Our Ref: BR/38/21/DOC

Town & Country Planning Act 1990 (as amended)
Town and Country Planning (Development Management Procedure) (England) Order 2015
Approval of details reserved by condition imposed under BR/175/20/PL relating to Condition Nos 4 -
proposed brick bonding and 5 - joinery details.
23 Mead Lane Bognor Regis PO22 8AP

Arun District Council have decided to **REFUSE details reserved by condition for the following reasons:**

Picture – Infill wall elevation.

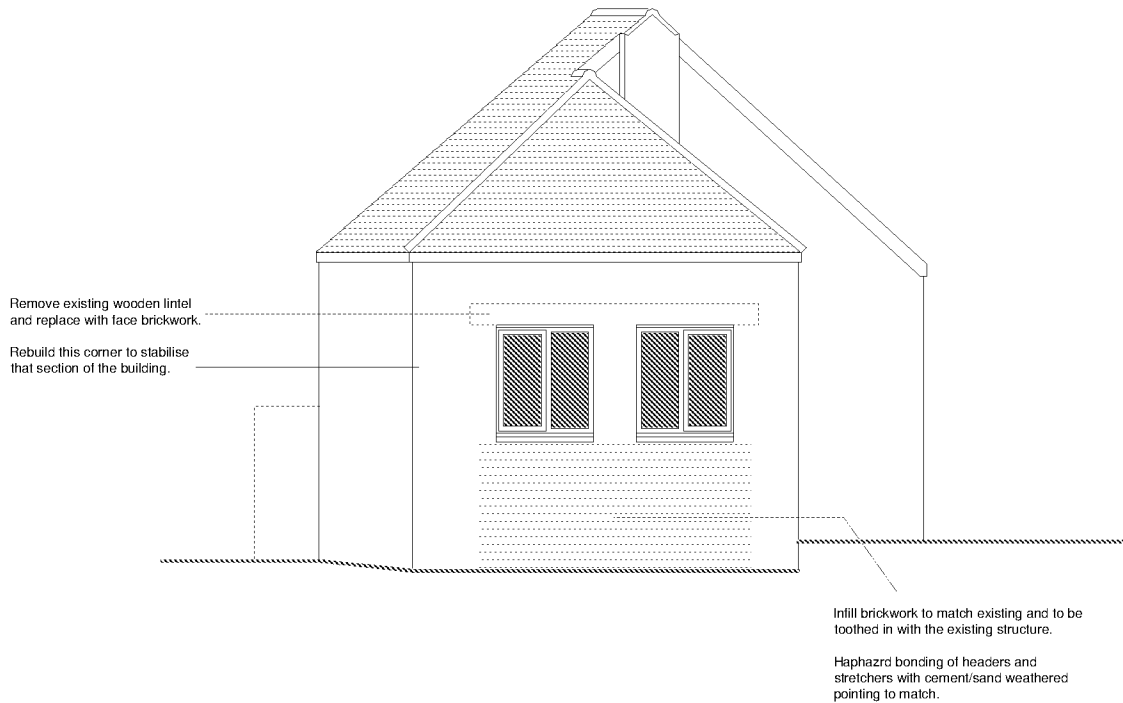
The documents submitted in respect of the infilled northern brick wall are not considered to be acceptable and sufficient to satisfy the requirements of this condition. No details of the proposed brick bonding were provided as required by condition 4. Provided 'Picture 1 Infill wall elevation' can't be in any respect considered as a detail of the proposed brick bonding.

As such, the condition 4 cannot be discharged and you will need to make a revised submission.
